Your Ref: OWPC23327
Our Ref: M/42/19/PL 10-05-2019
Please ask for:
Andrew Wood

Demolition of existing dwelling & erection of pair of semi-detached chalet dwellings with on-site parking facilities & new vehicular access.

117 Elmer Road Elmer

Thank you for your internet representation made on 2nd June 2019 which has been recorded as **'an objection'** with the comments as follows:

sheet 3 of 4

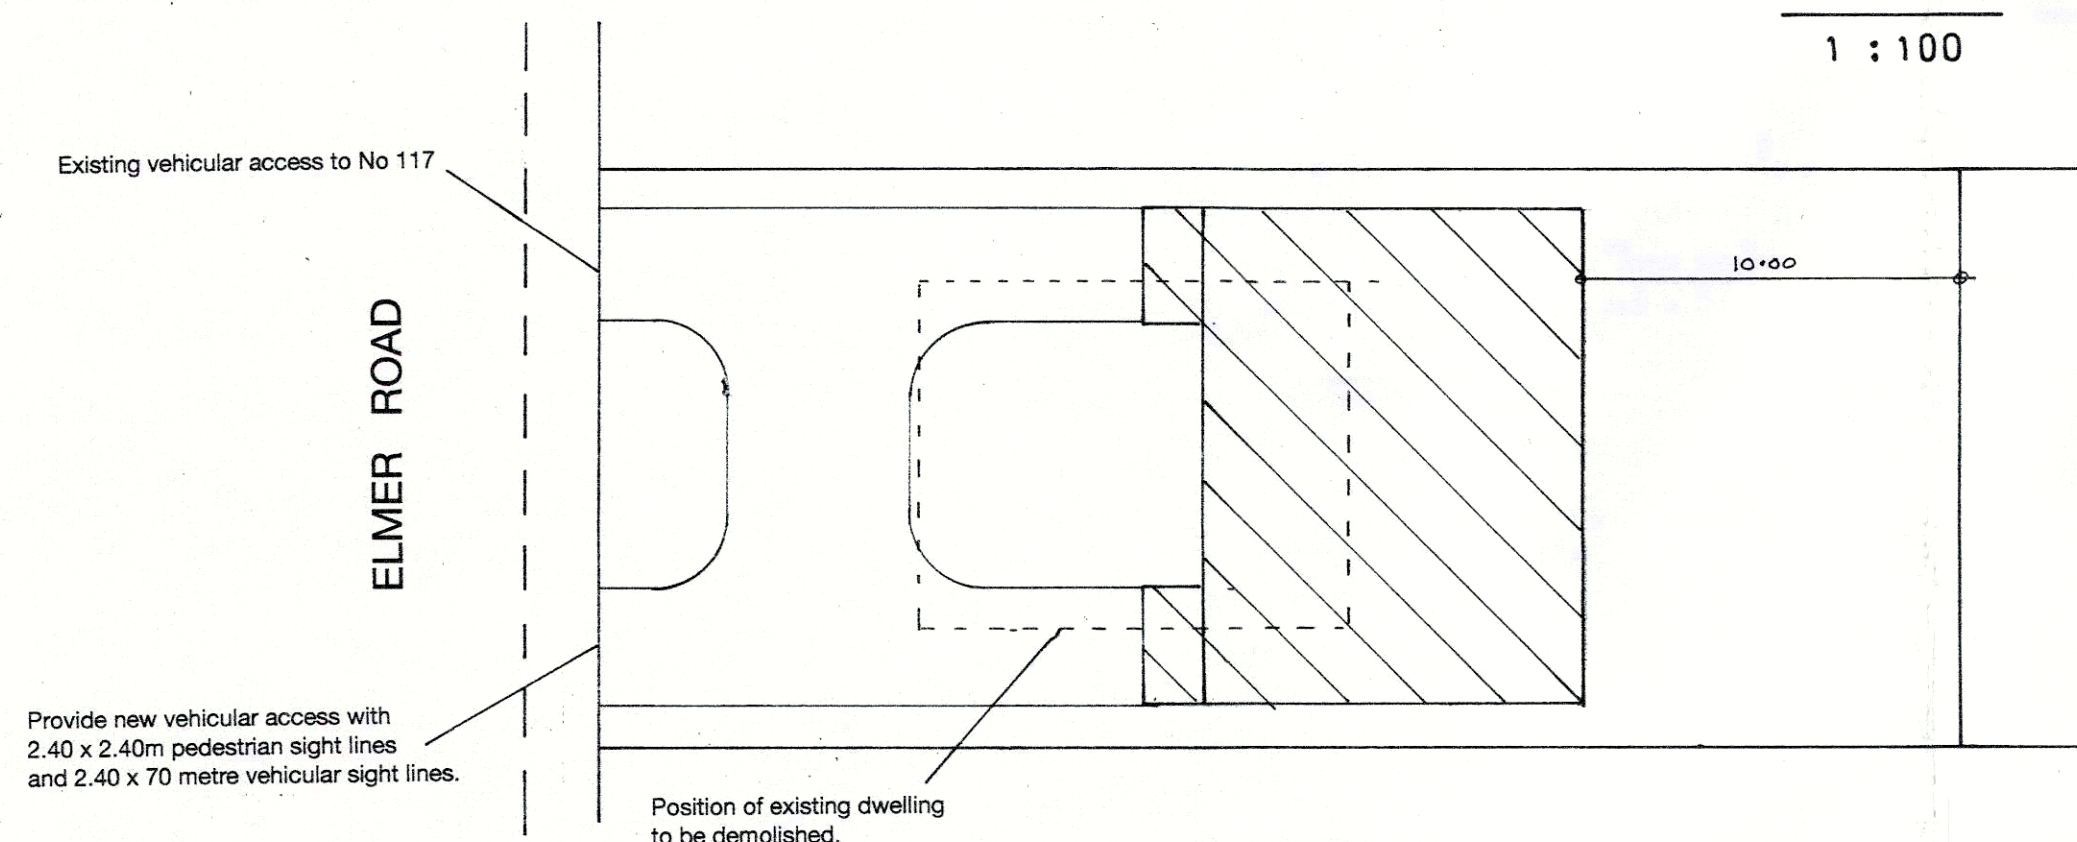
1) HEIGHT: It is very clear the proposed properties will be much taller than the current property. I oppose this totally; erecting a much taller structure is much akin to a "change of use" of the site. It will result in more natural light being blocked from my property and also importantly greatly reduce my privacy due to the large amount of windows being introduced at a higher height than existing. When I look out of my south facing lounge and dining room I already have 115 and 115a directly in front of my bungalow. If this goes ahead all I will see is a row of rooves and windows that impact my light and privacy. I purchased my bungalow 20 years ago because it was a nice open area and not significantly overlooked by higher properties - something that this will take away. It will also make me feel totally enclosed behind a wall of higher properties and make my property less desirable.

sheet 1 of 4

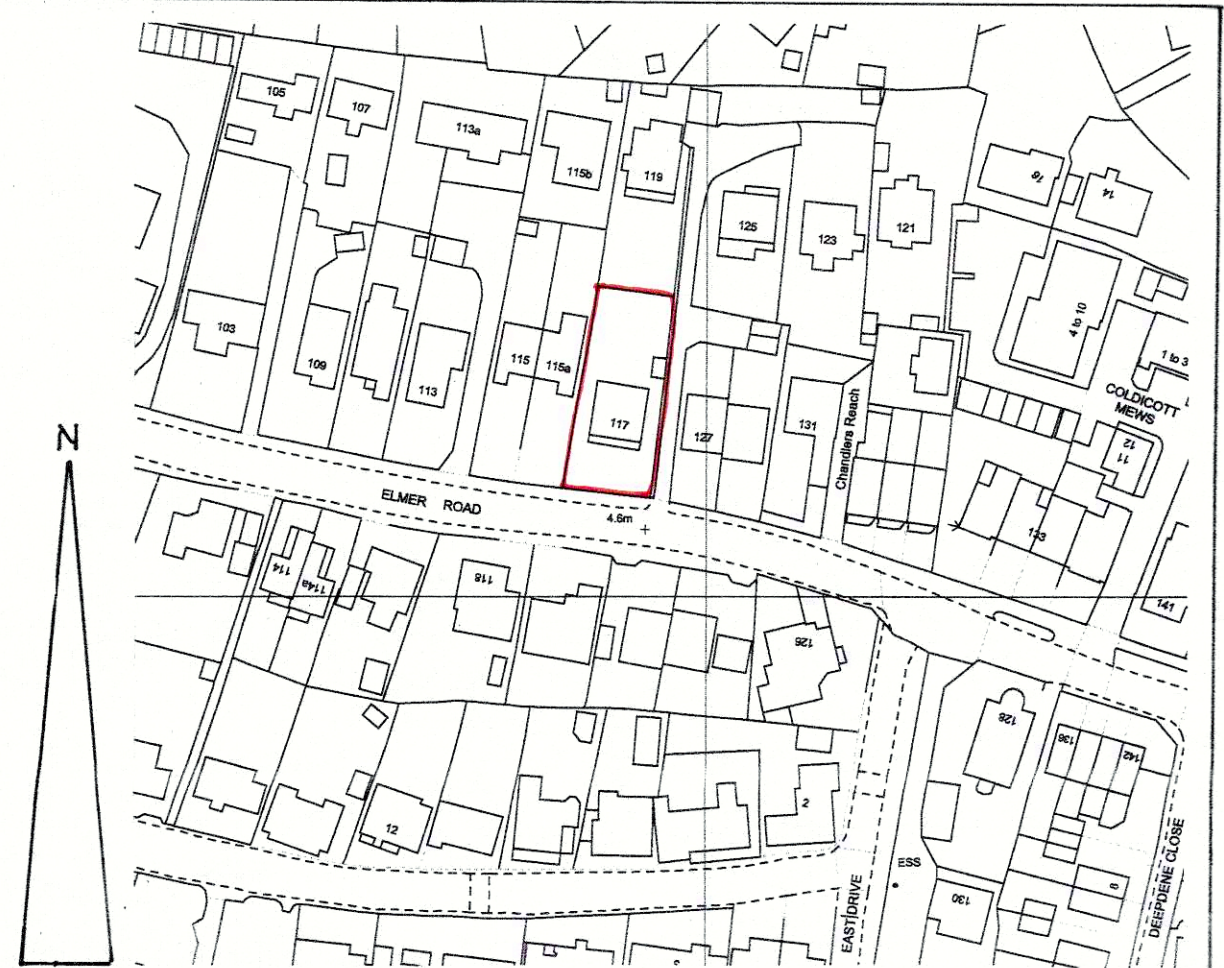
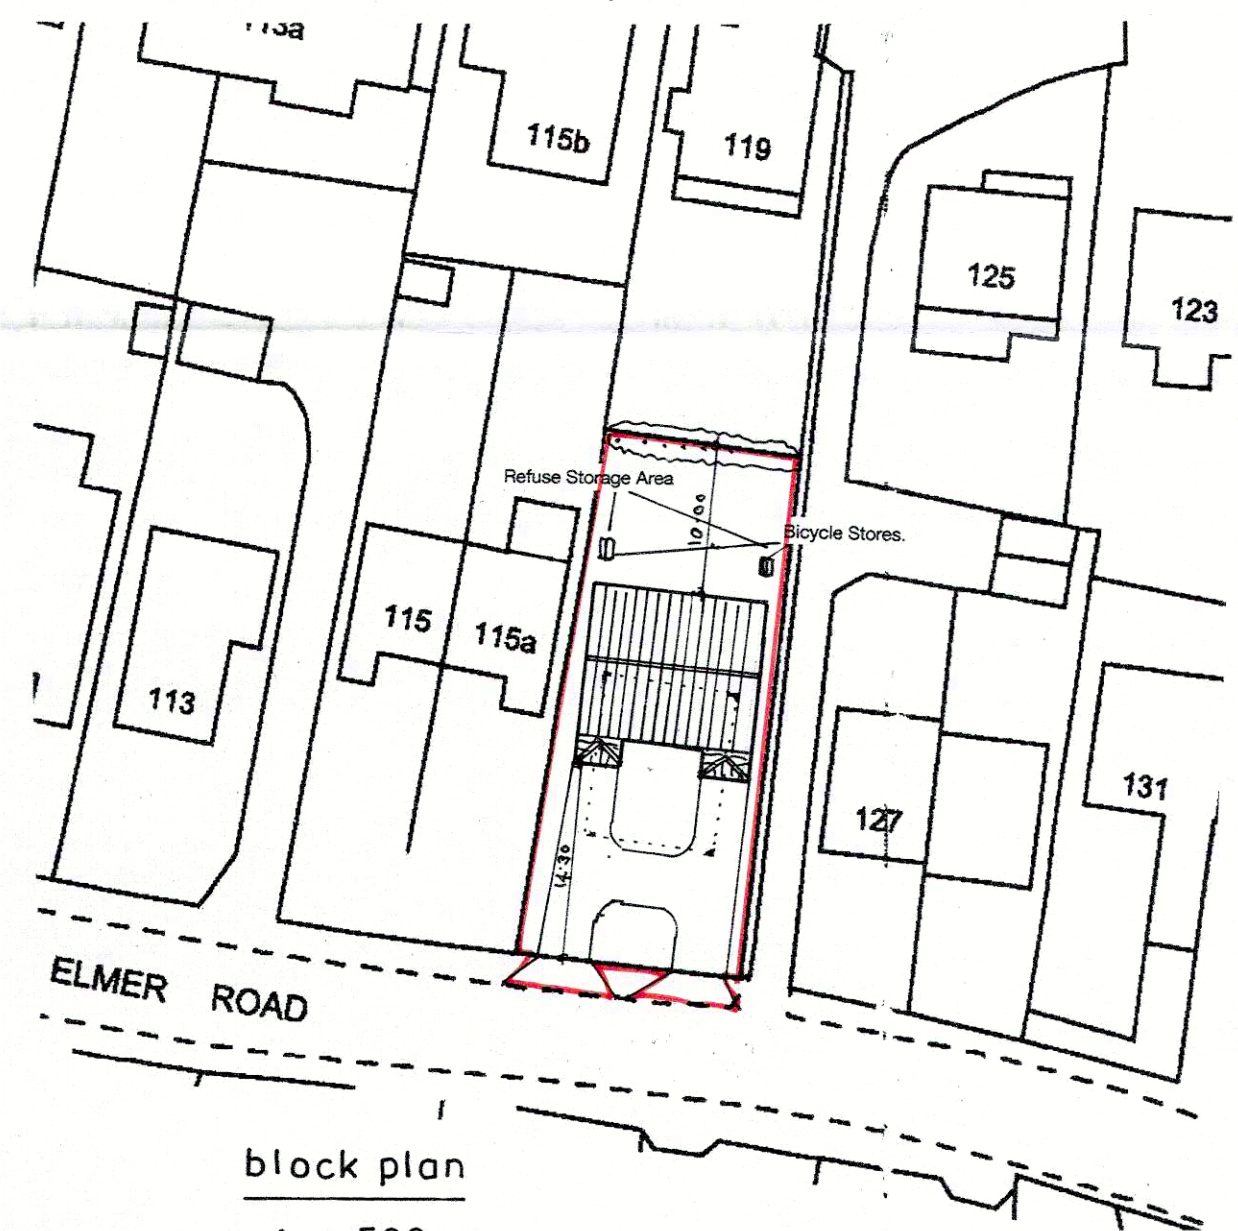
3) FOOTPRINT: It is both unnecessary and unacceptable to set the proposed development back further from the road than the existing property. It should be built on the current footprint and importantly to the same height as the existing property or single storey. Failure to do so will significantly impact my natural light and privacy.

sheet 2 of 4

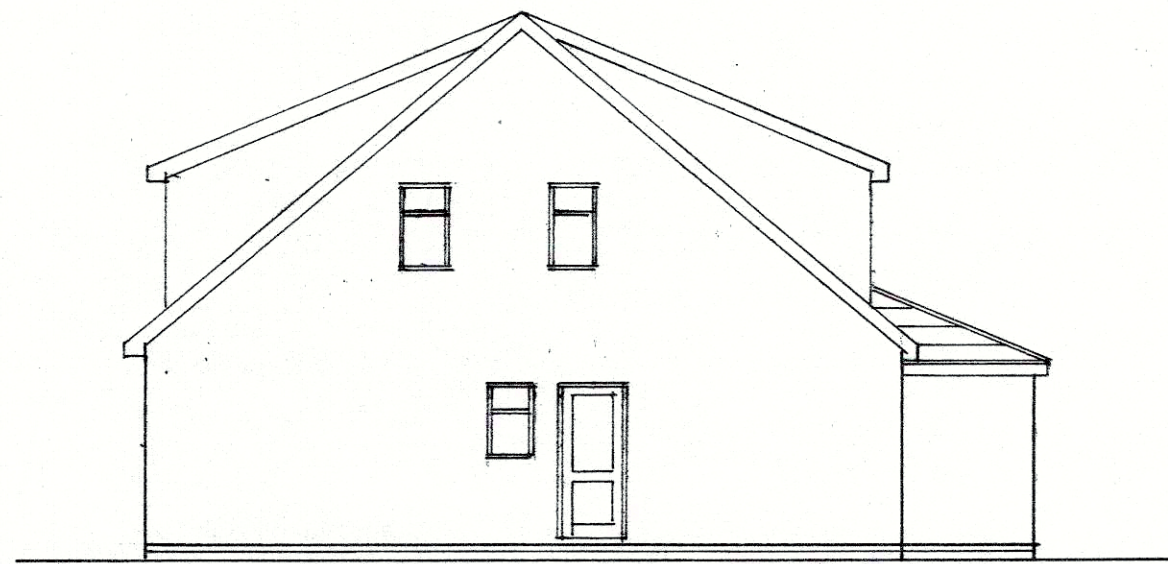
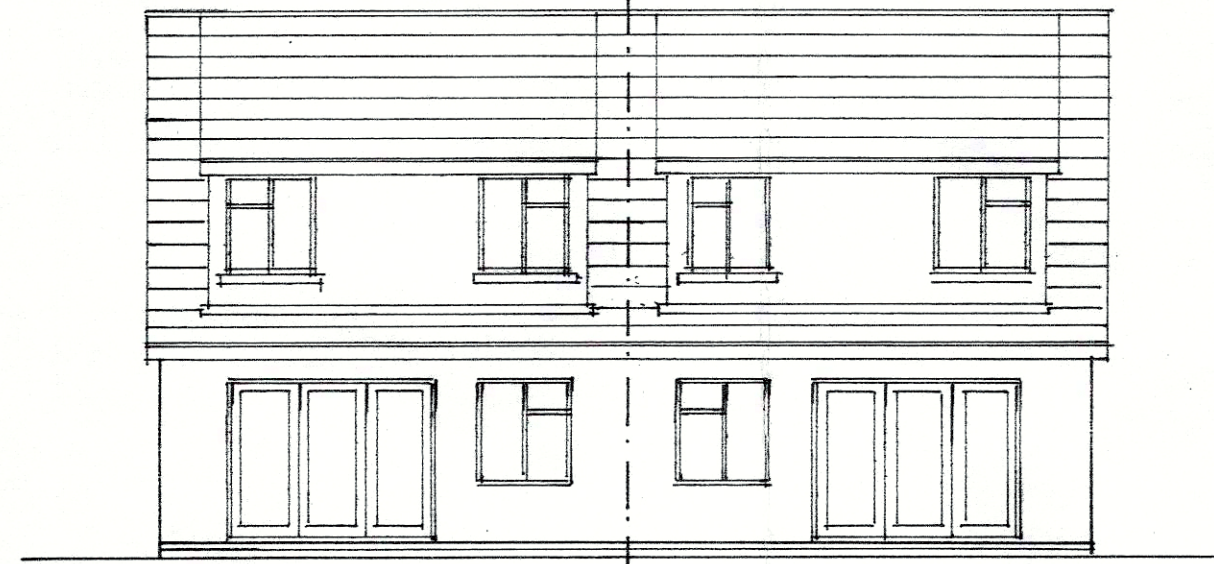
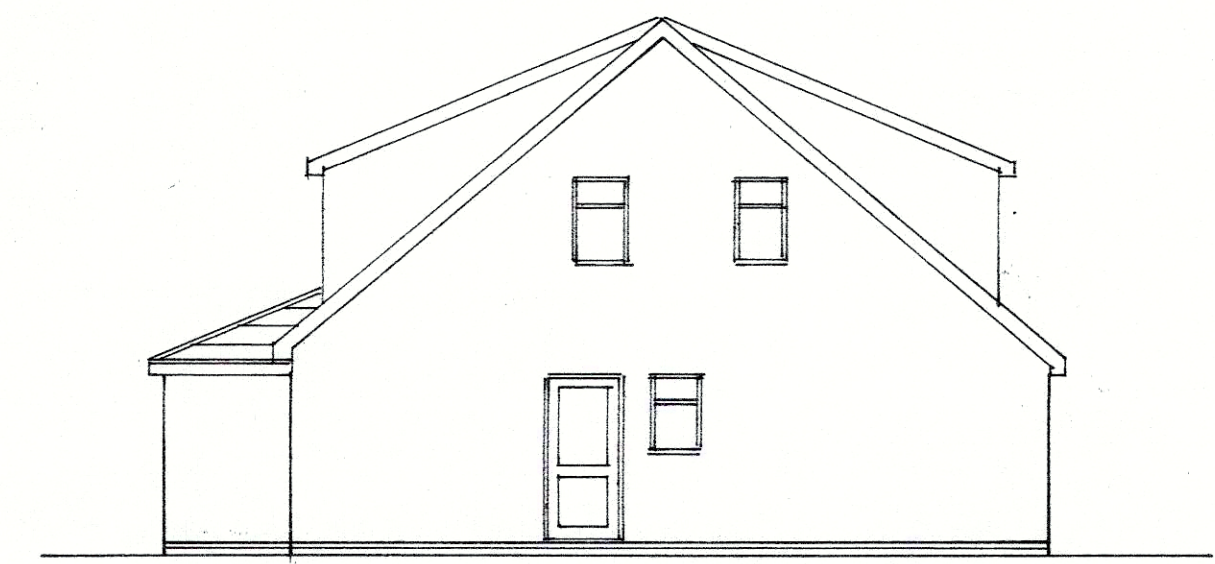
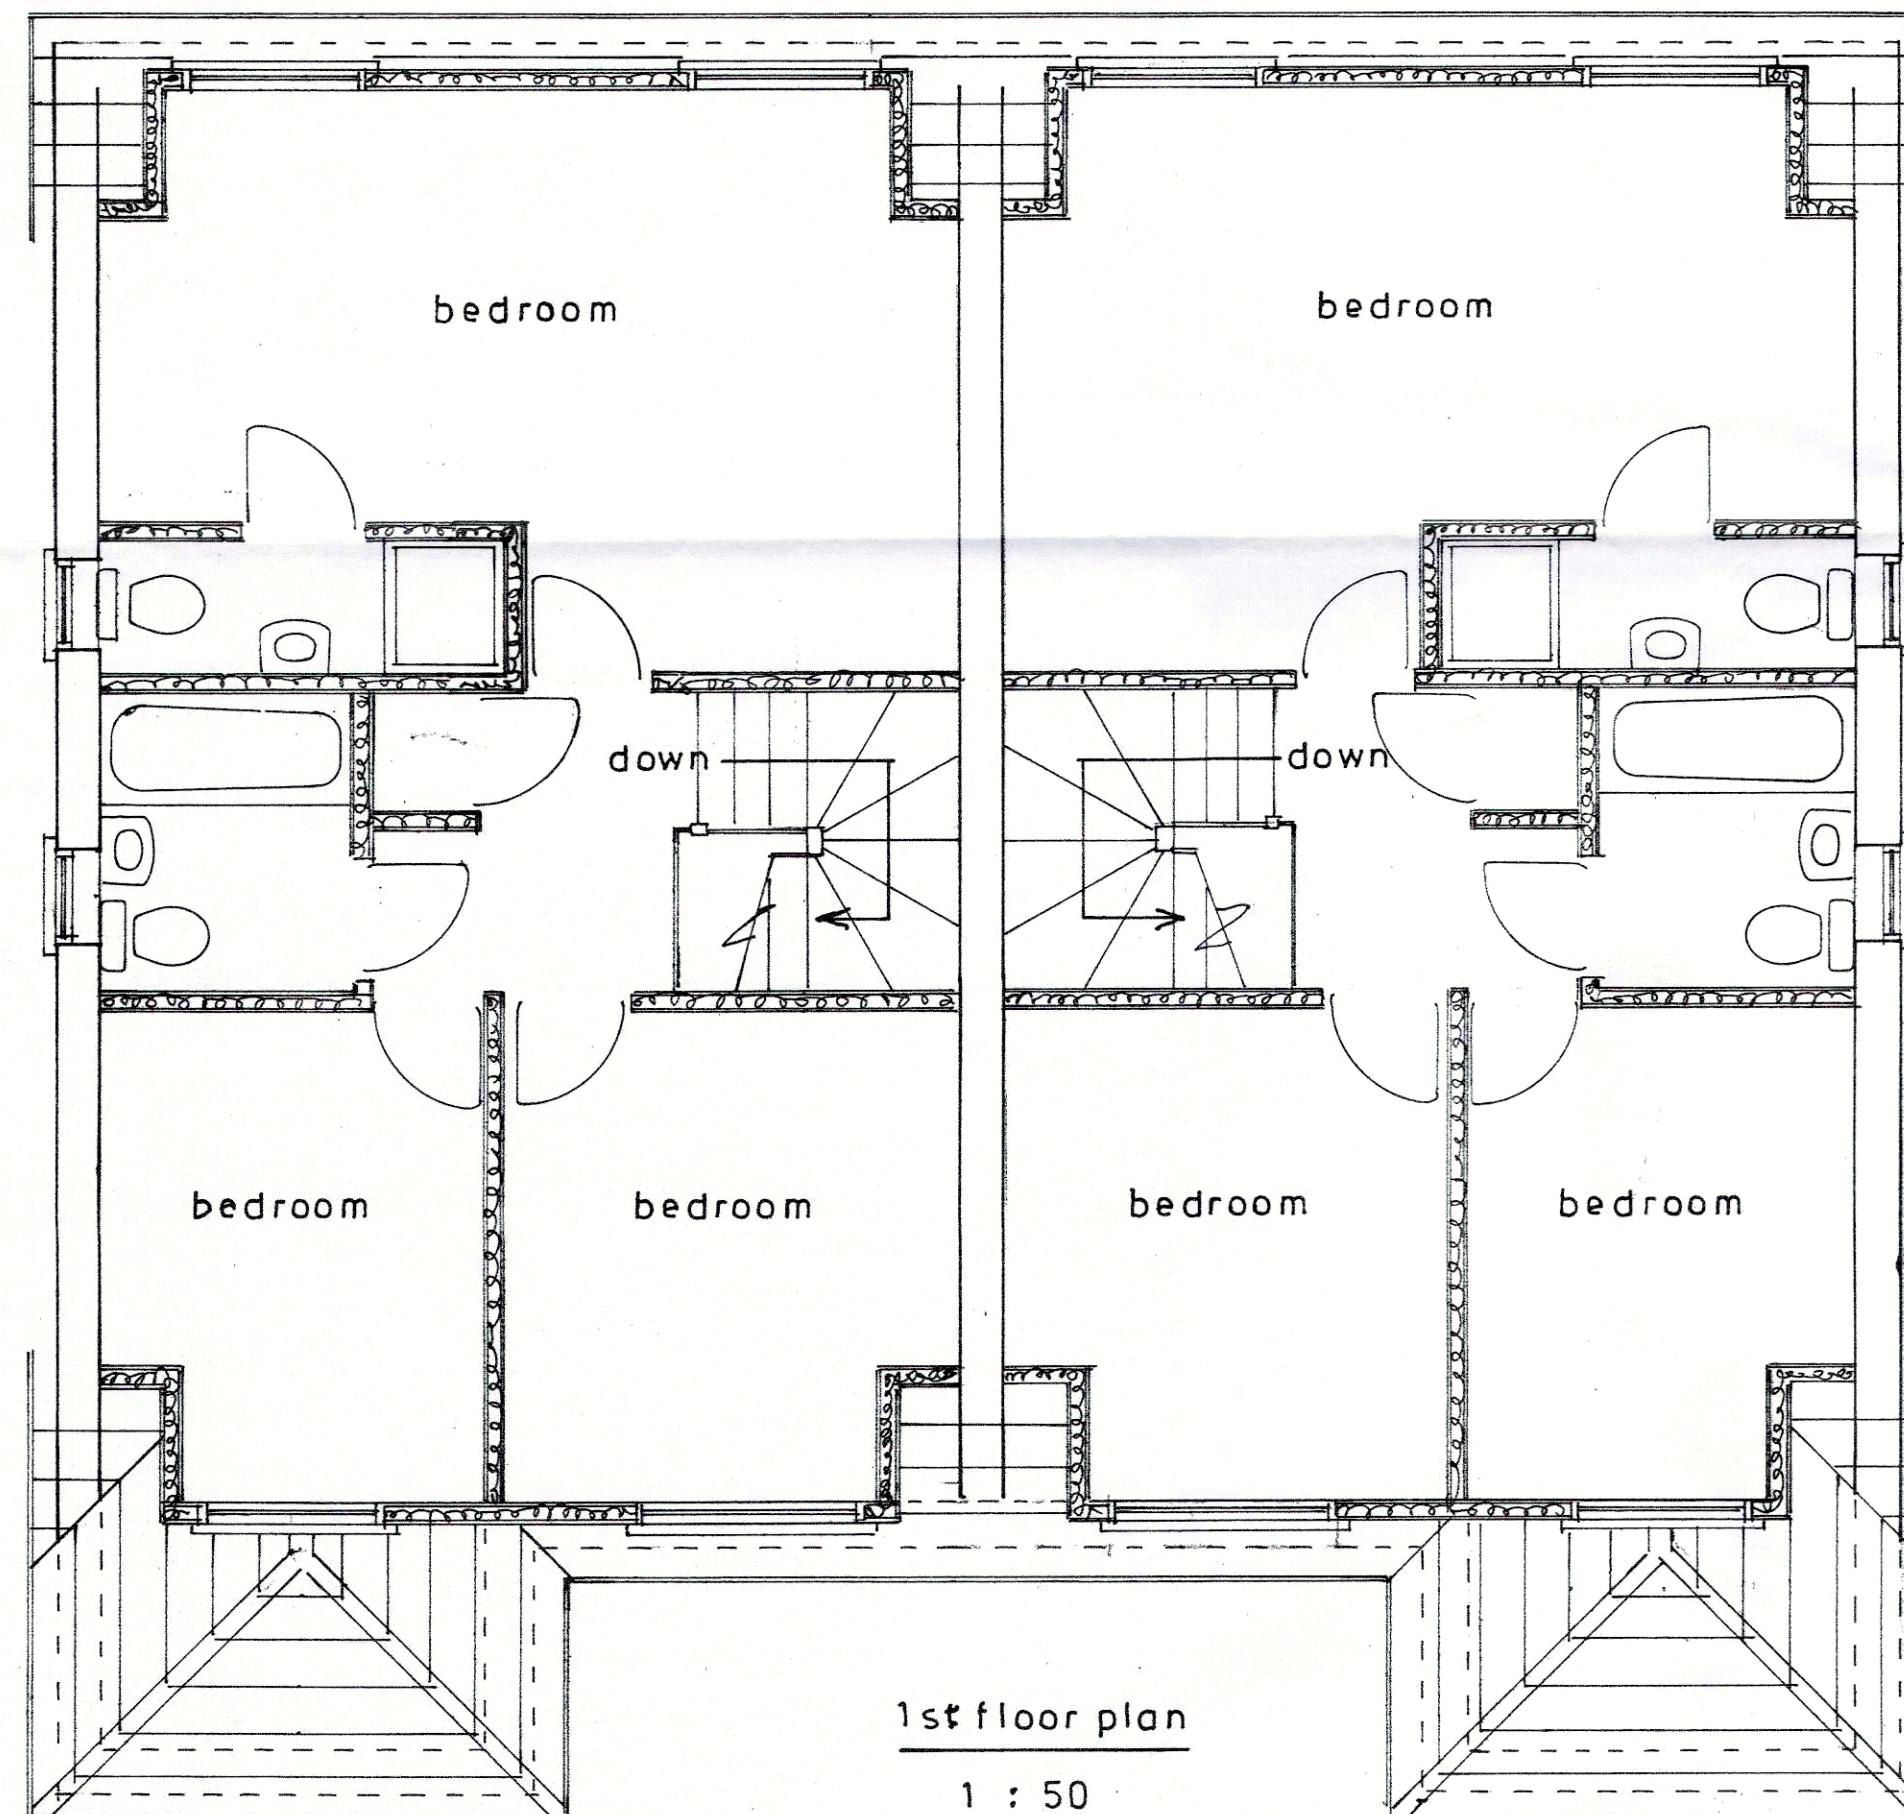
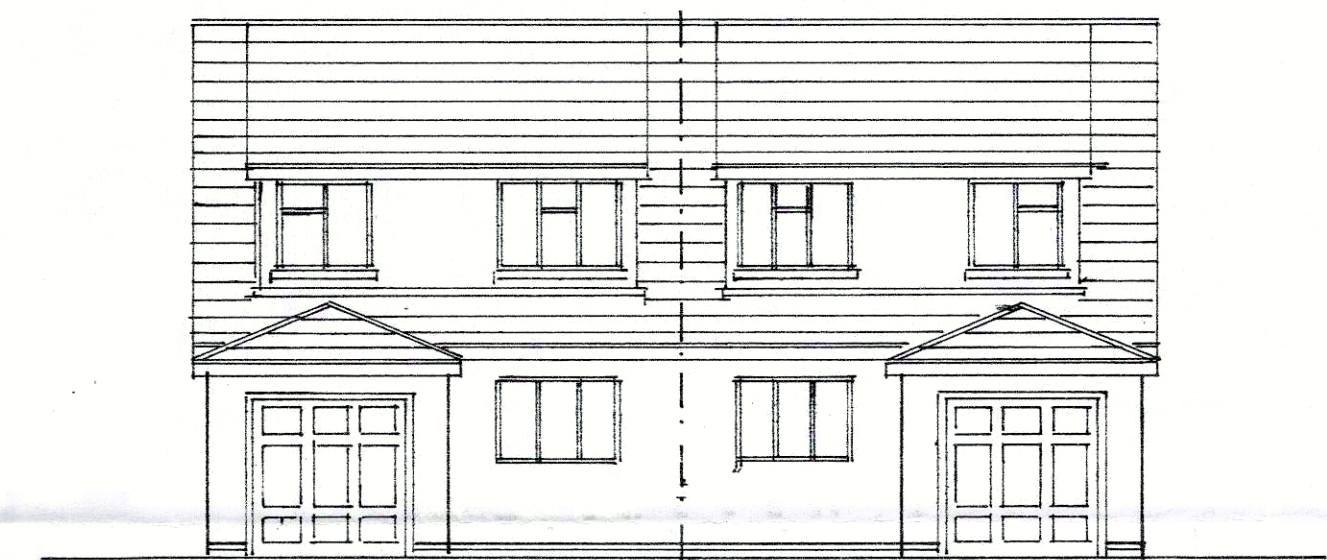
2) PRIVACY: The existing property has one window on the north elevation at a relatively low height. The proposed development would introduce 6 new windows overlooking my property from the first storey which is clearly unacceptable - specifically 4 on the north elevation and 2 on the west elevation.

4) OVERLOOKING STATEMENT: The "Planning, Design and Access Statement" says "The proposal has been designed to fit both into the street scene and protect the present amenities of adjacent properties at No 115a and 127 Elmer Road with no overlooking". It clearly hasn't been designed to protect the present amenities of adjacent properties at No 115b and 119 Elmer Road with no overlooking! Why not? How about the overlooking you are proposing to introduce to my property 115b and to 119. You seem to have overlooked the fact that introducing two properties that are higher than the existing property and have 6 times as many windows than the exiting property on the first storey (north and west elevation) will massively increase overlooking!
